**CAMPUS
IMPROVEMENT
PROGRAM 2014–2020**
STATE-SIGNIFICANT
DEVELOPMENT
APPLICATION (SSD 13_6123)
SEPTEMBER 2014

SUPPLEMENTARY
RESPONSE TO
SUBMISSIONS

KEY ISSUES - CIP RESPONSE TO 2ND ROUND OF AGENCY SUBMISSIONS SEPTEMBER 2014

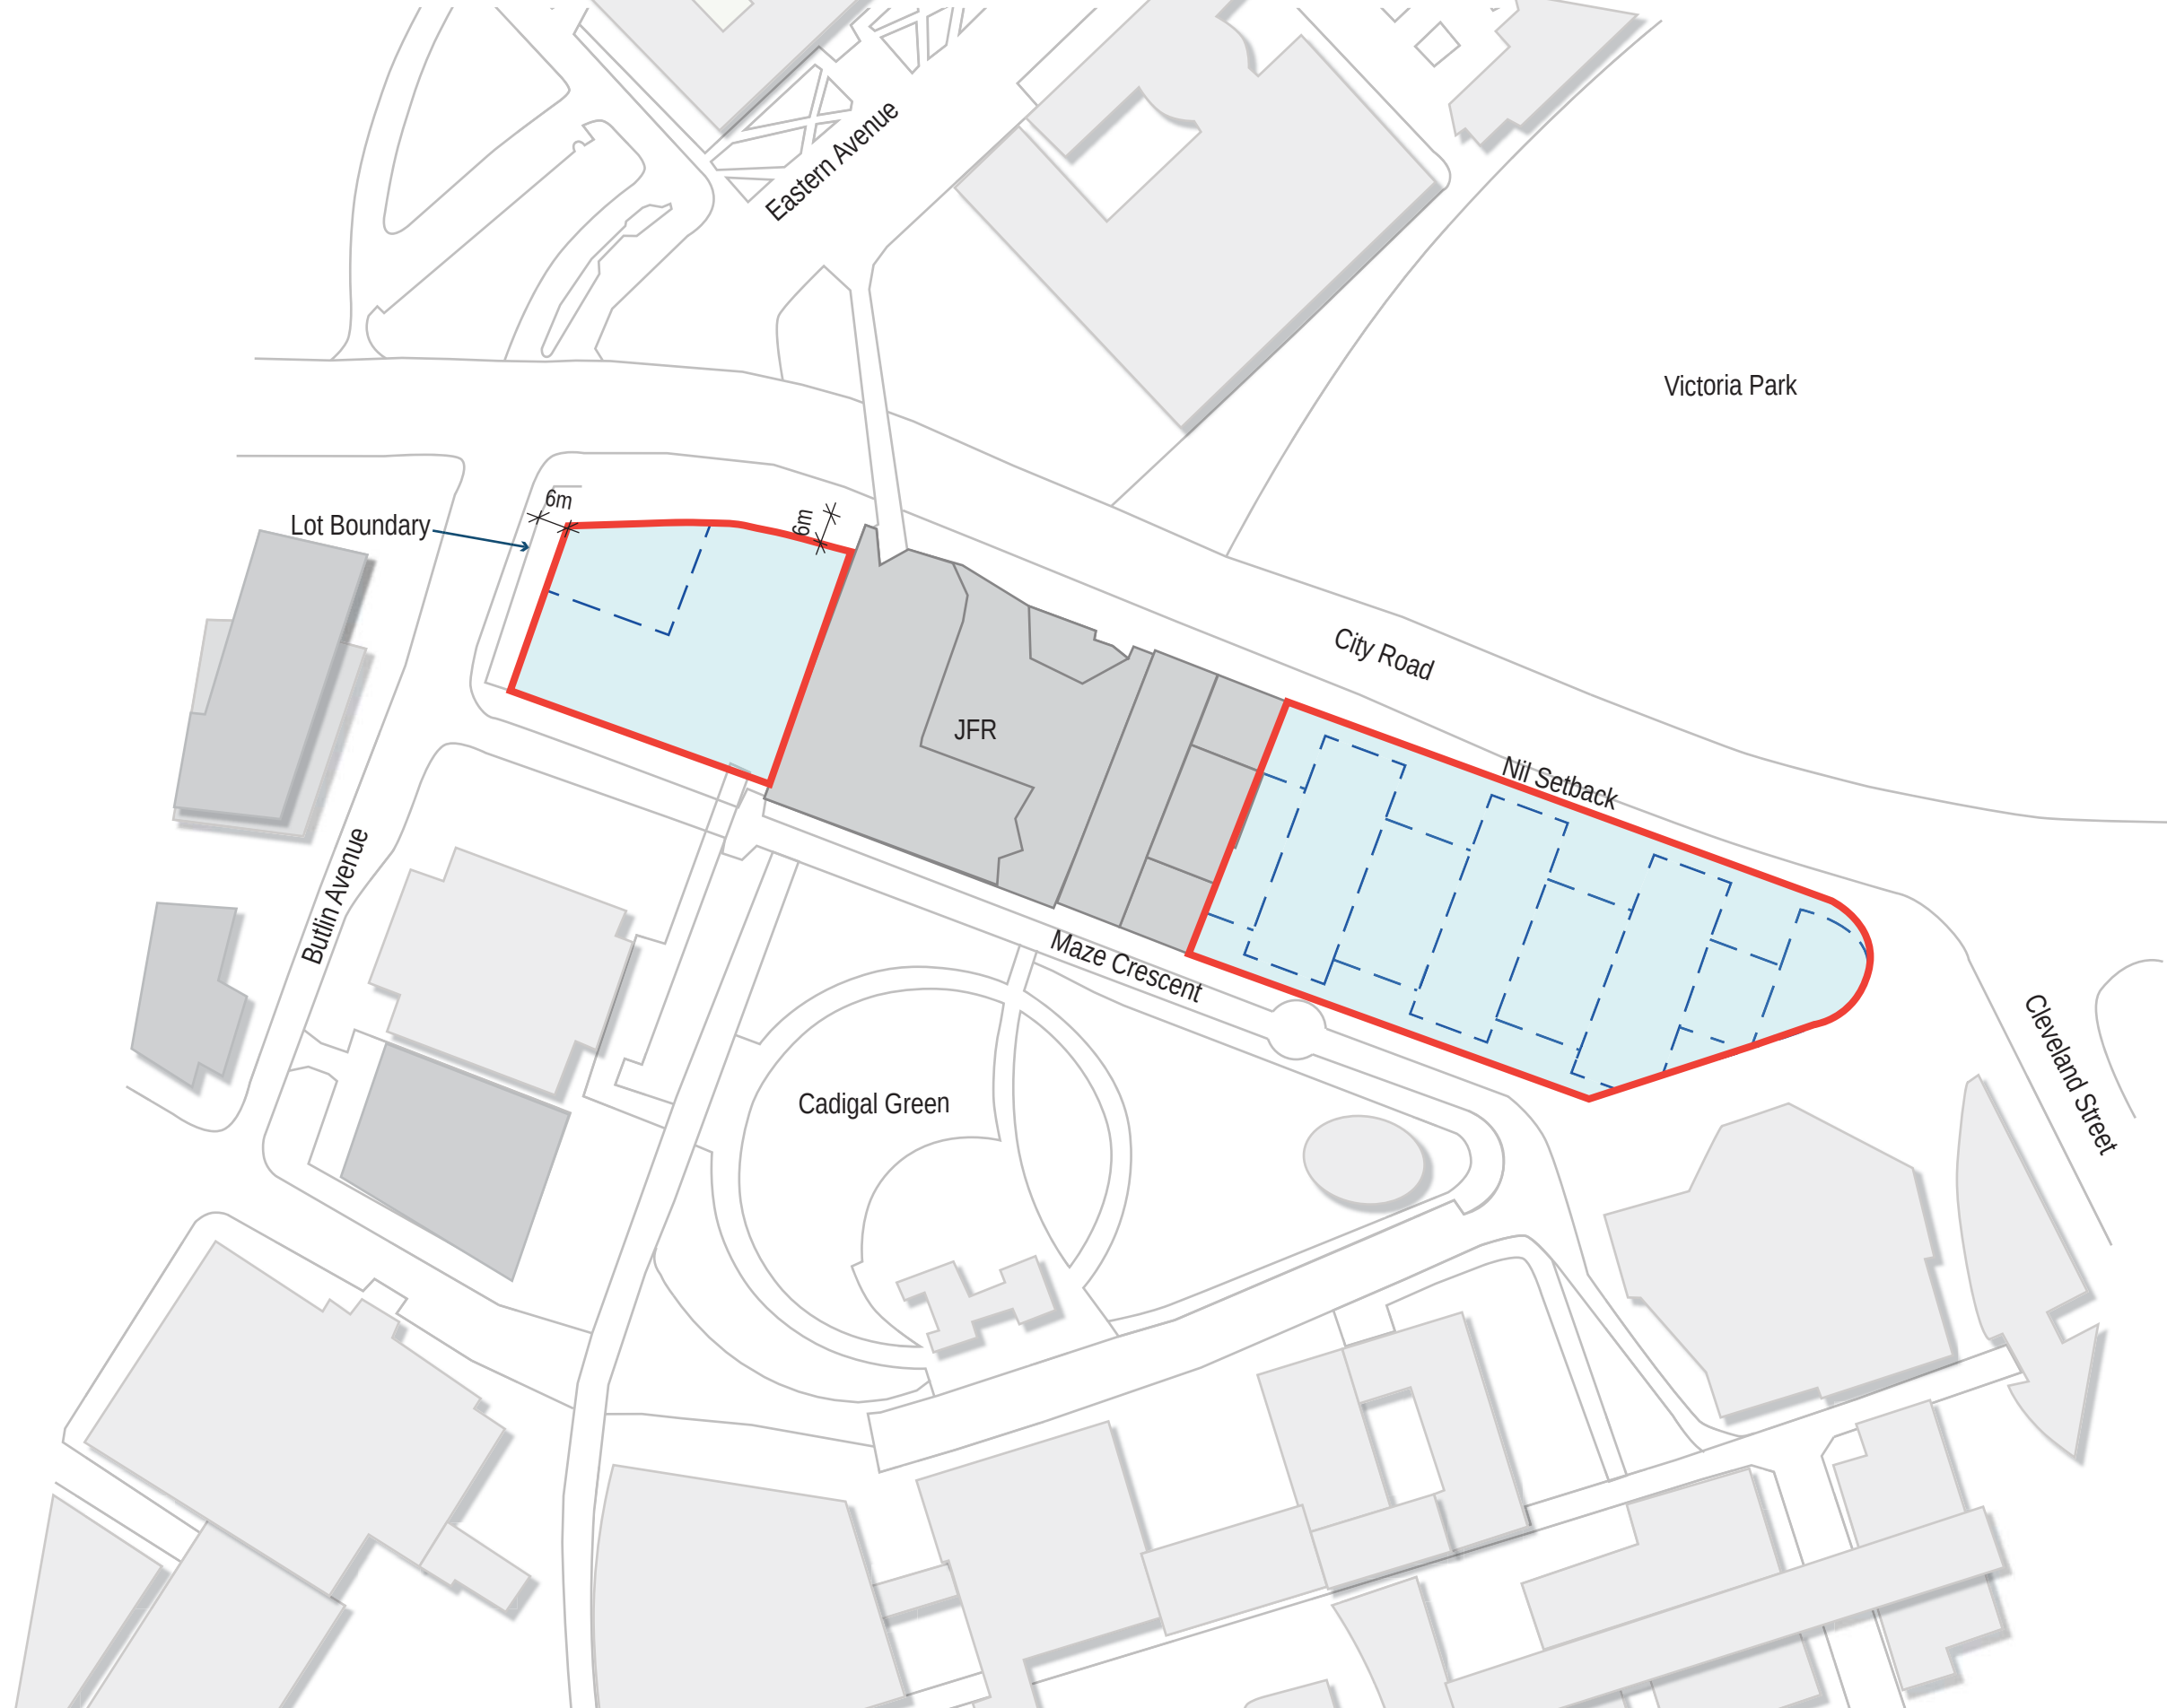
The University's RtS refers to producing a 6 metre setback from City Road, yet the precinct envelope plans refer to "Nil Setback" in the area.	Amended Plan SSD-B-11 (see comments above). To clarify the University's intention, and to avoid further confusion, the words 'Nil Setback' are removed from the CIP City Road Envelope Plan drawing SSD-B-11.

01 MEREWETHER - PROPOSED ENVELOPE PLAN

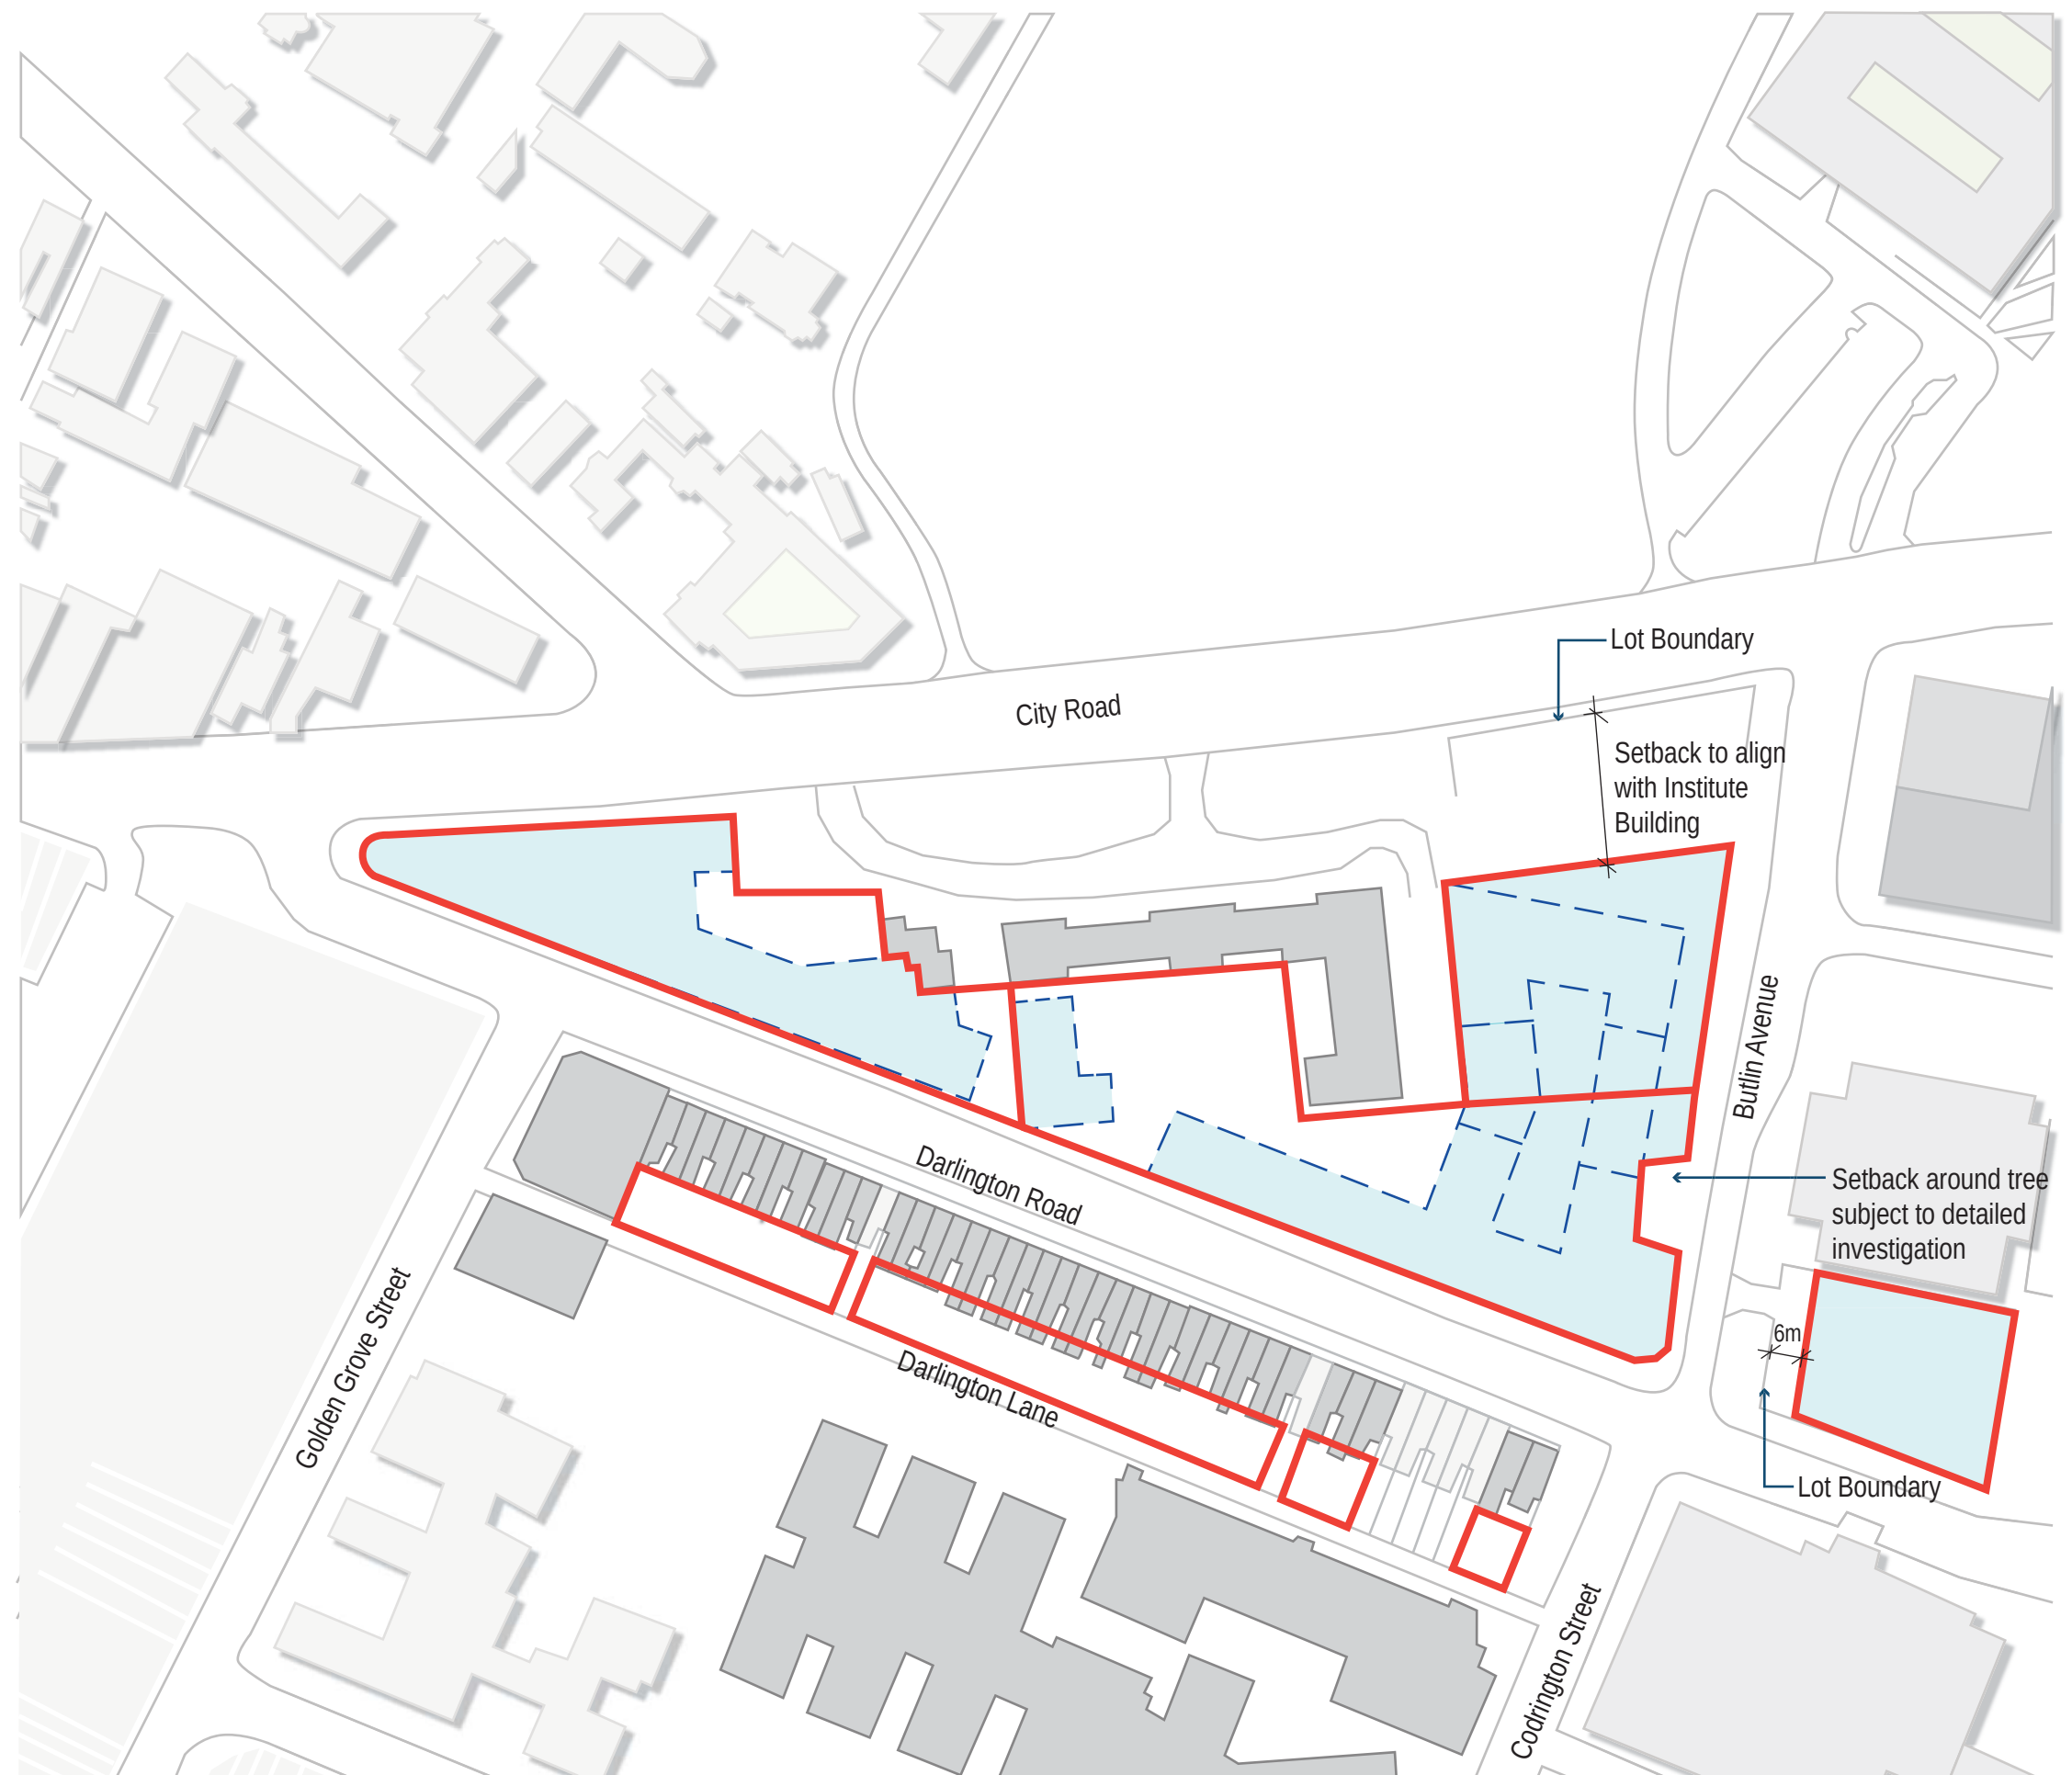
Setback the building envelope 6 metres from Butlin Avenue instead of a 'nil setback'. (NEW Heritage Council)	Clarification – Amended Plan SSD-C-11: The Merewether Precinct 'building envelope' represents the area within which future buildings, open space, landscaping and access arrangements can be accommodated. Appropriate building setbacks from Butlin Avenue will be addressed and designed as part of a future detailed design application and will respond to existing site conditions including existing trees and heritage fence elements (see comment above). To clarify this intention, and to avoid further confusion, the words 'Nil Setback' are removed from the CIP Merewether Building Envelope Plan drawing SSD-C-11.

Drawing no:	SSD-D-11
Date:	08-09-2014
Drawn by:	CIS
Checked by:	JC

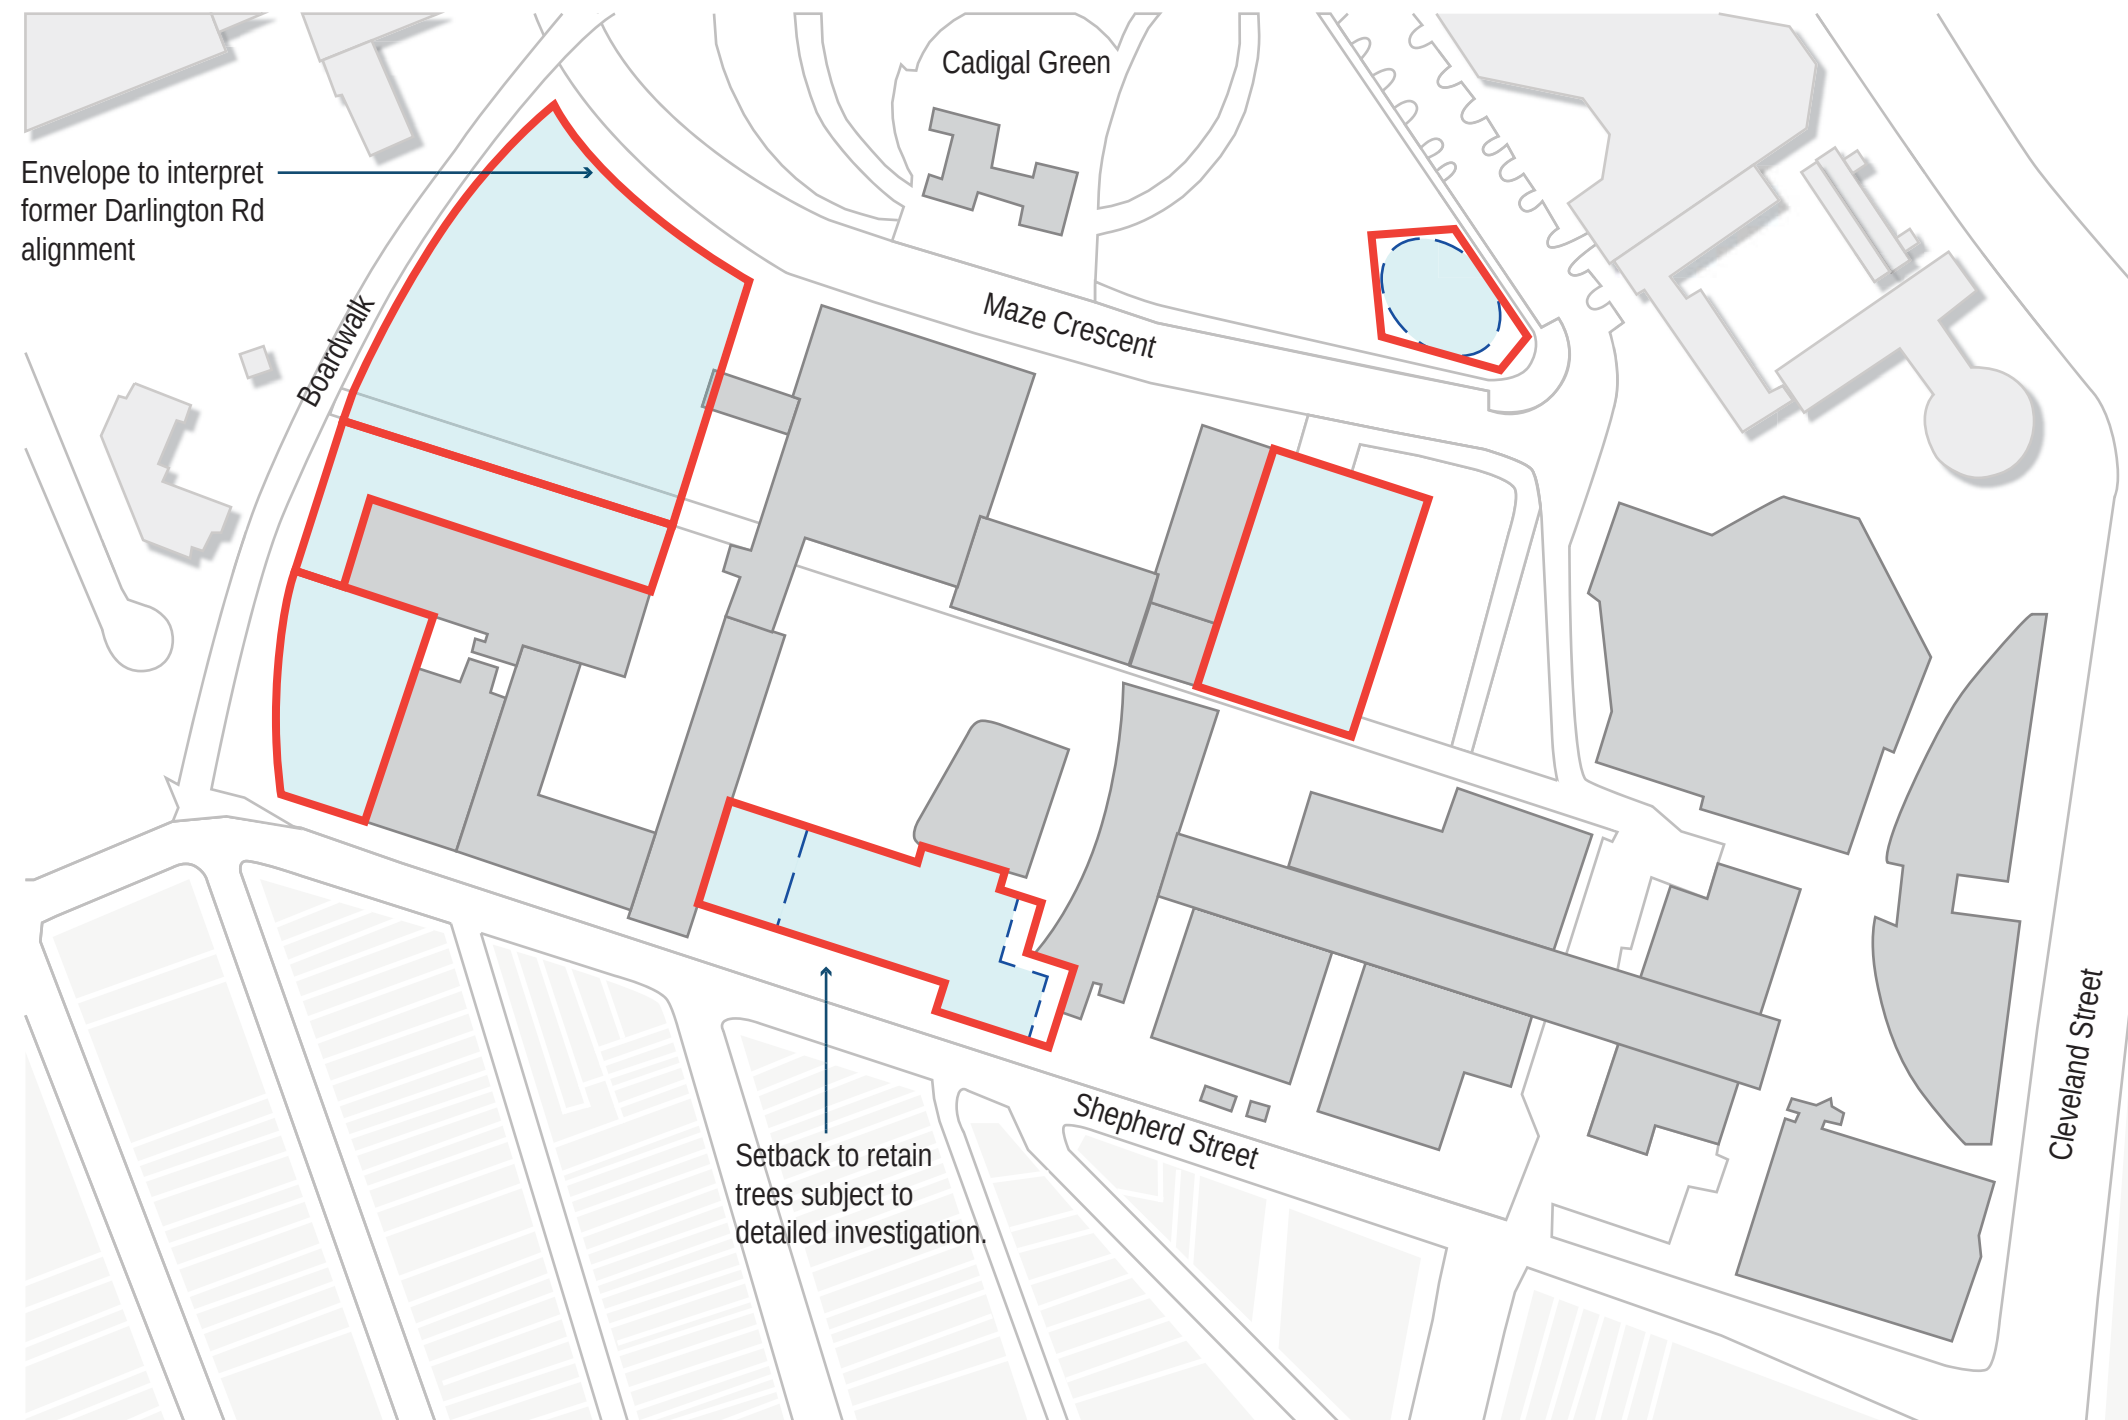
ISSUE	THE UNIVERSITY OF SYDNEY- CIP RESPONSE
	Pedestrian View Along Boardwalk Looking Northwest Amended Plan SSD-D-11: The Chemical Engineering envelope is amended by setting back the northern footprint to interpret the former Darlington Road alignment through campus. The CoS has verbally encouraged this initiative. This vista will be incorporated into the future design brief for the redevelopment of the Chemical Engineering site.
